Project Name:	Land at Bayards, Eastergate (Miller Homes)
Document Reference:	091.5016/SVR/7
Document Name:	SuDS Verification Report – Area 7
Prepared By:	Samuel Flesher
Checked By:	Meagan Weedon
Approved By:	Jon Soar

- 1.1 This Sustainable urban Drainage Strategy (SuDS) Verification Report – Area 7, has been prepared by Paul Basham Associates on behalf of Miller Homes to support the 'As-Built' verification report to Arun District Council in relation to Land at Bayards, Eastergate.

- 1.2 This Verification Report has been prepared to support the discharge of Planning Condition 24. The report authors are Paul Basham Associates Ltd. Paul Basham Associates were established in 2009 and are a multi-disciplinary Transport Planning, Civil and Structural Engineering Consultancy, employing a team of Civil Engineers.

Project No:	Scale (@A1):	Drawn:	Date:
EASTERGATE	1:200	BT	AUG 23
Drawing No:		Rev:	
EASTERGATE-HA-XX-DR-C-00001		I01

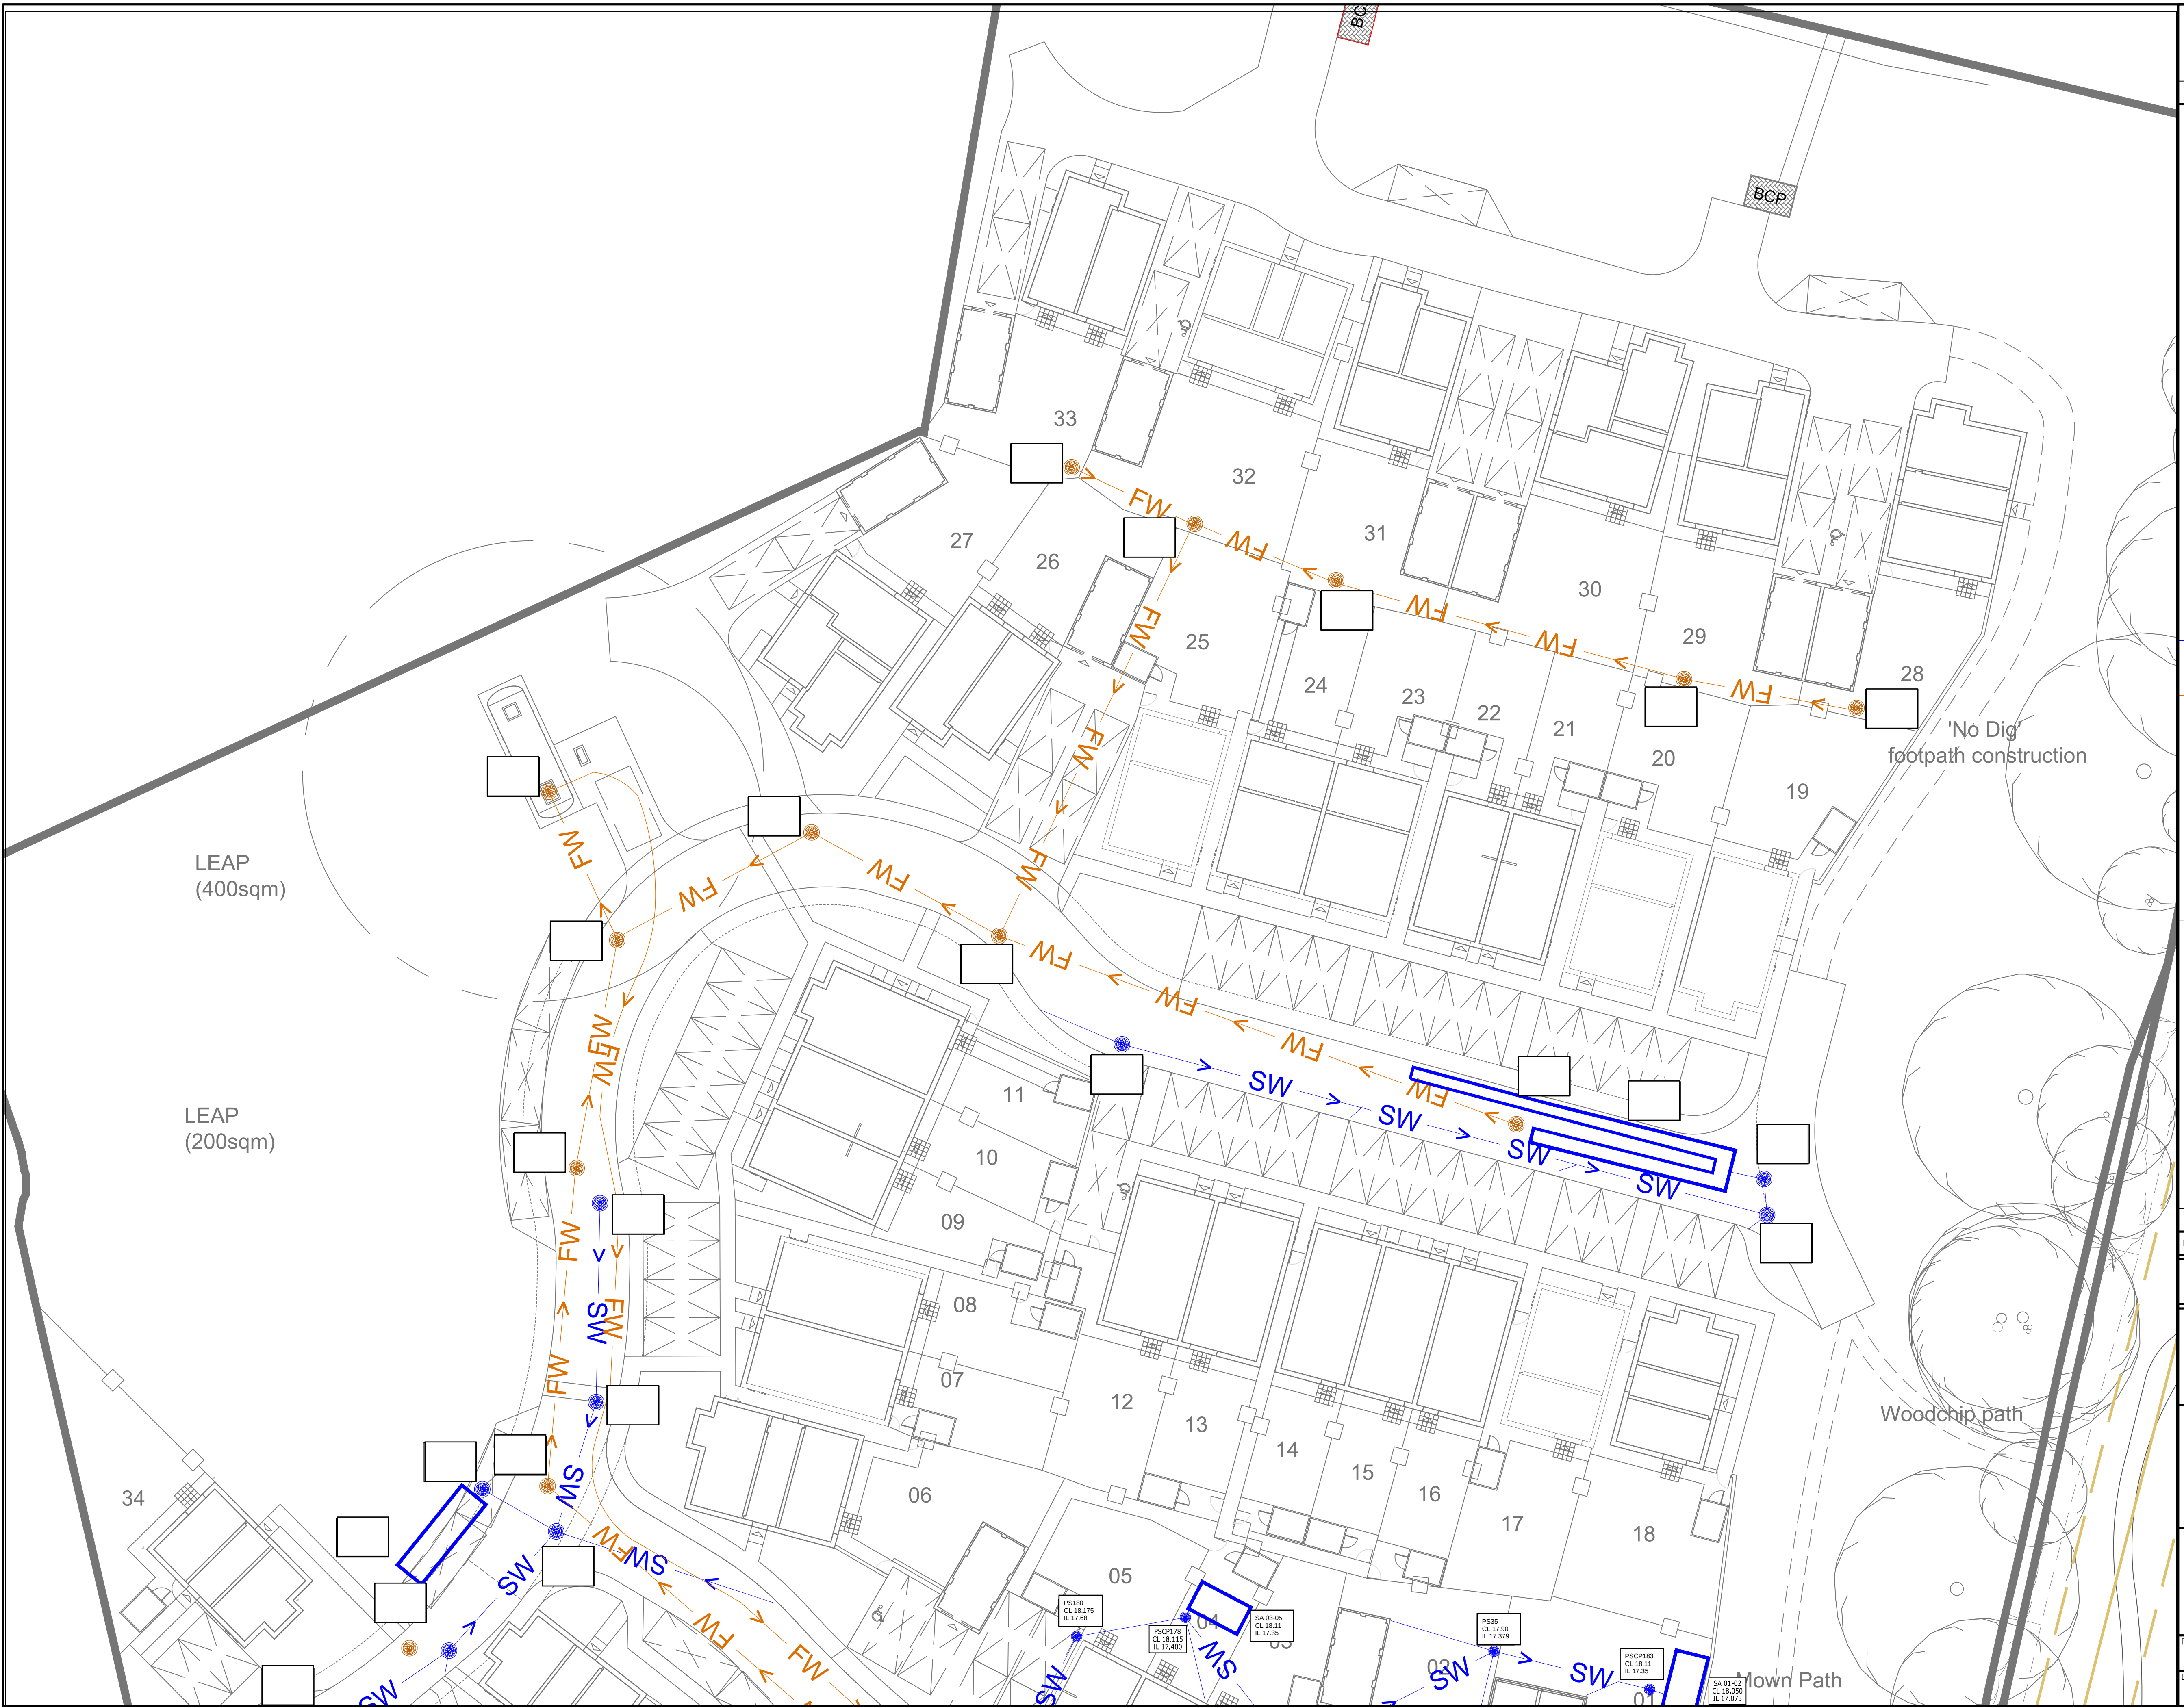
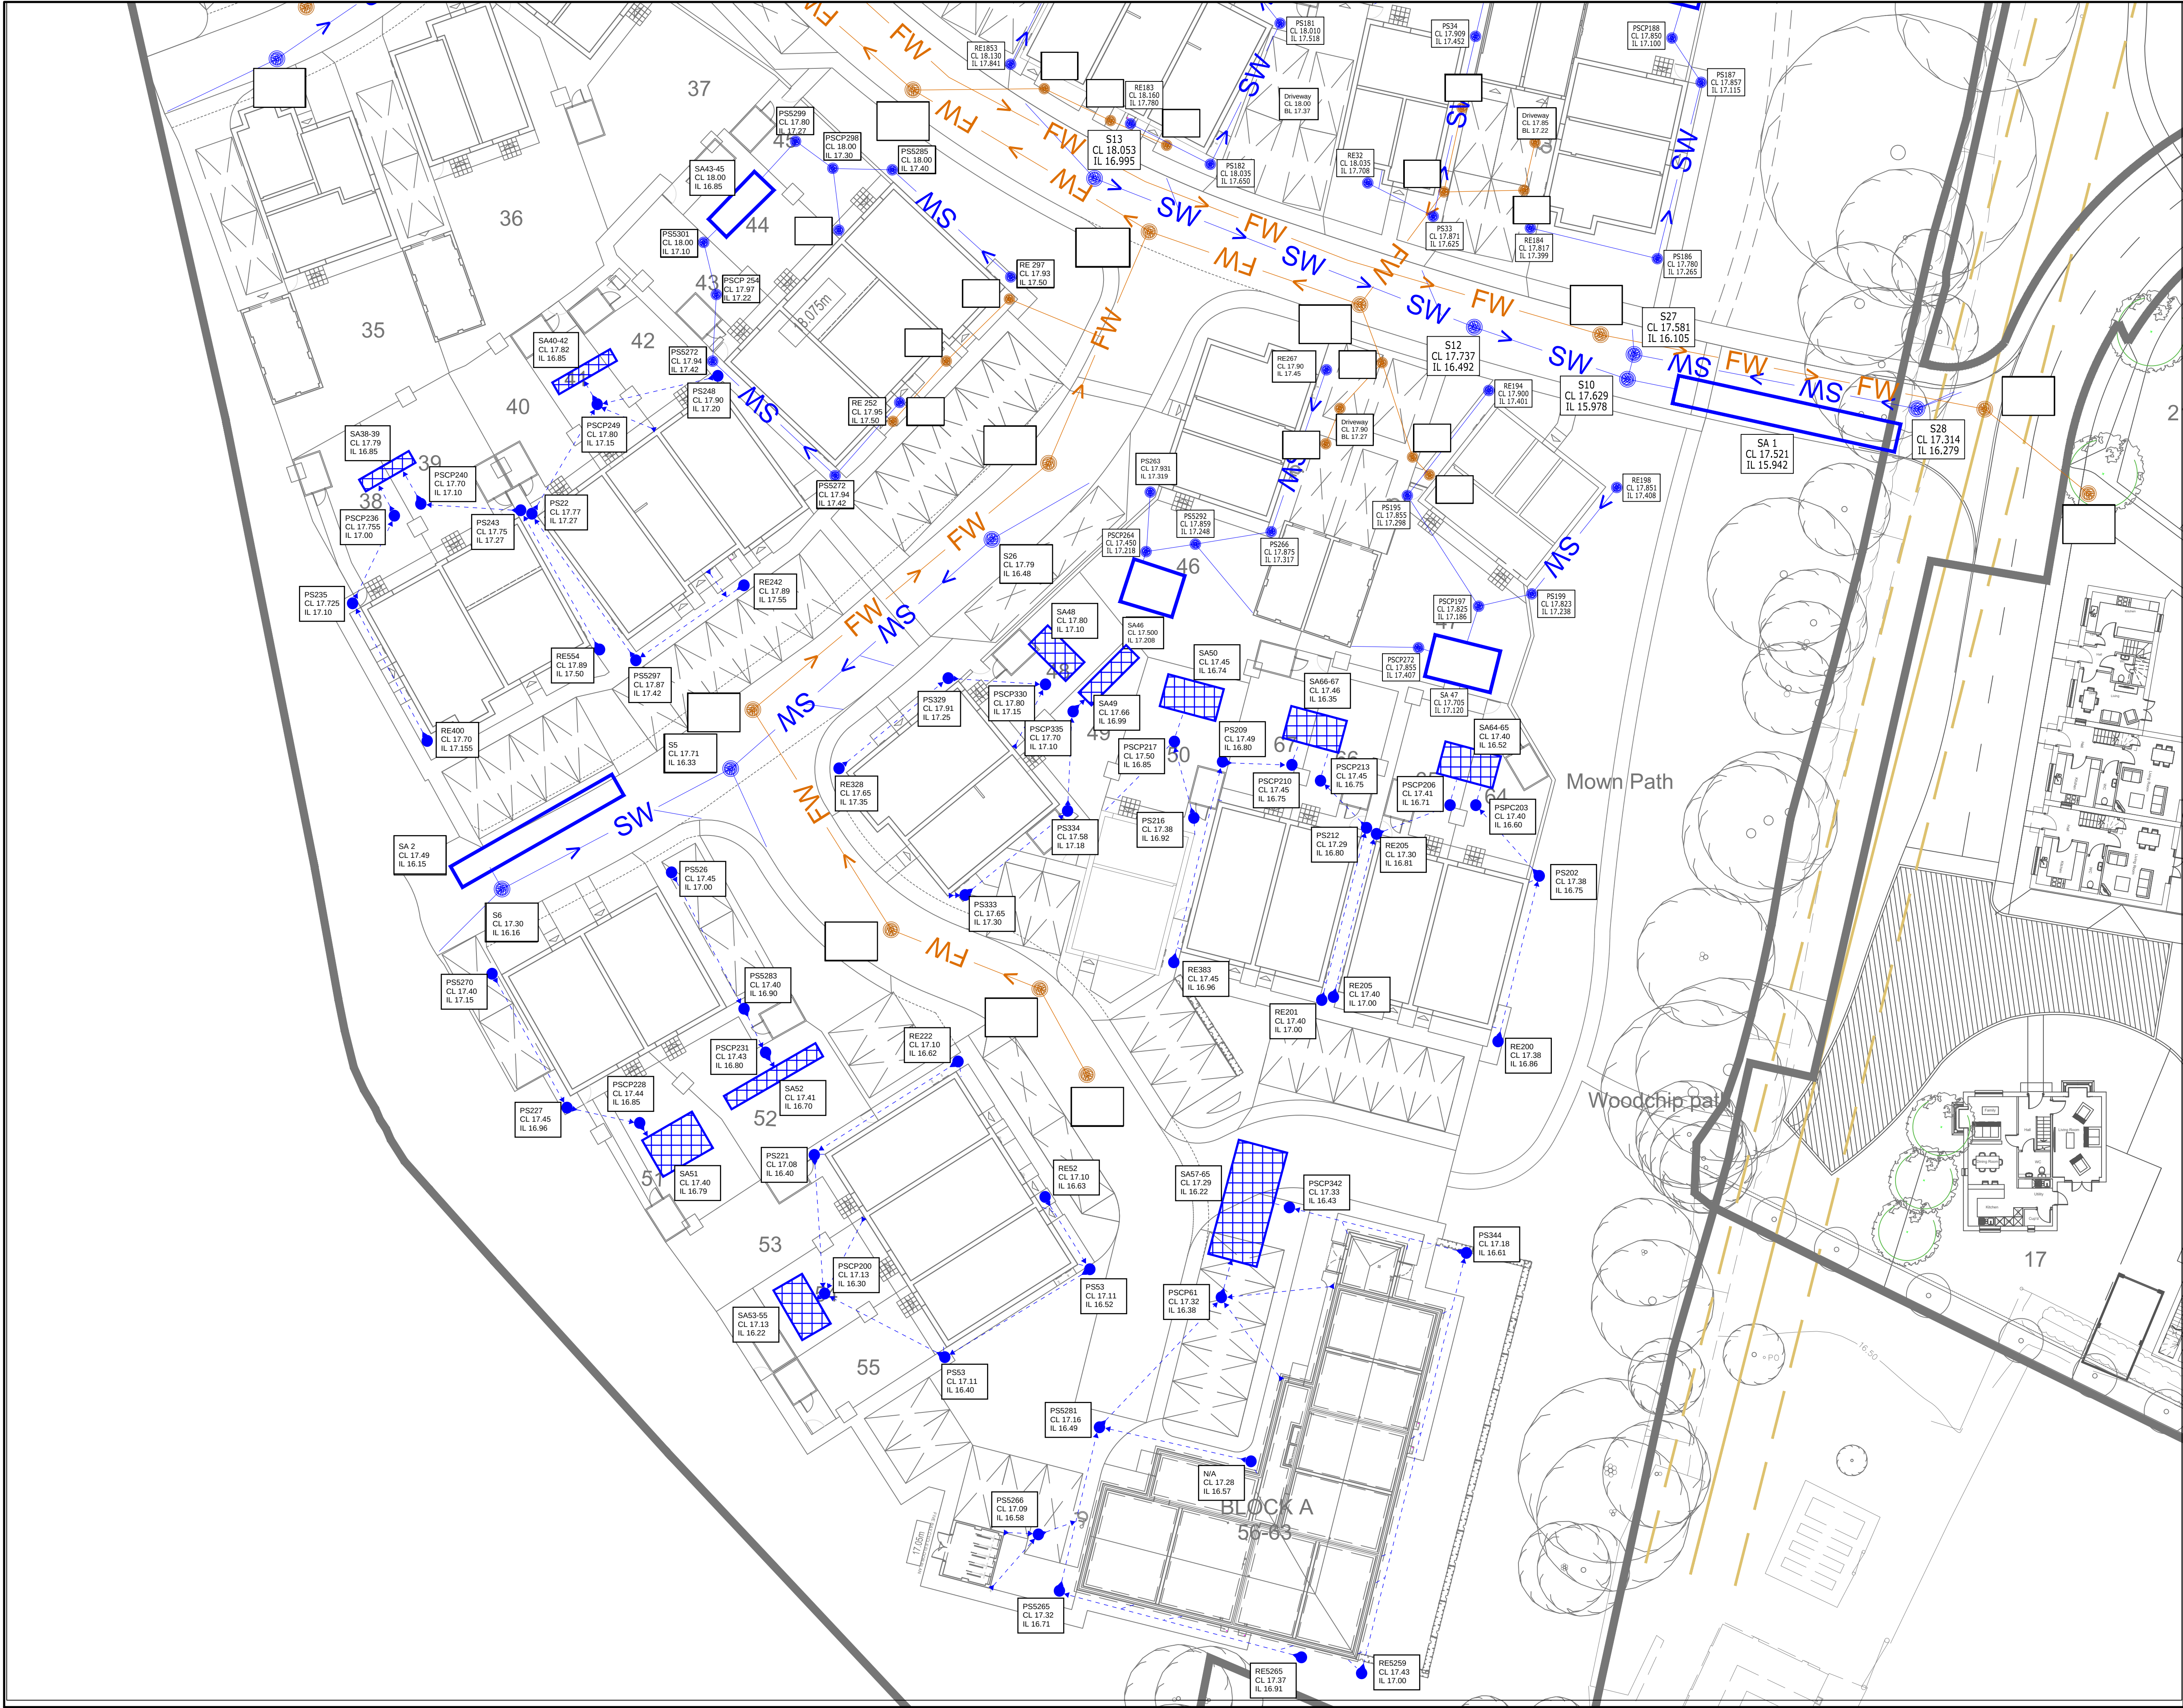
- 3.1 As-Built surveys of the site area and drainage systems have been carried out and the surveys are included as **Appendix C**.
- 3.1 These levels have been reviewed against the design levels shown in 091.5016.0501 C08, 091.5016.0502 C05 and 092.5016.0503 C06 the design drawings can be found in **Appendix B**
- 3.2 A tabulated summary of invert levels for chambers constructed within Area 7 is given below.

- 3.3 The comparison between the design and as built levels shown that the invert levels are generally within normal building site tolerances.
- 3.4 Cross checks of raised invert levels appear to show that no backfalls have been created.
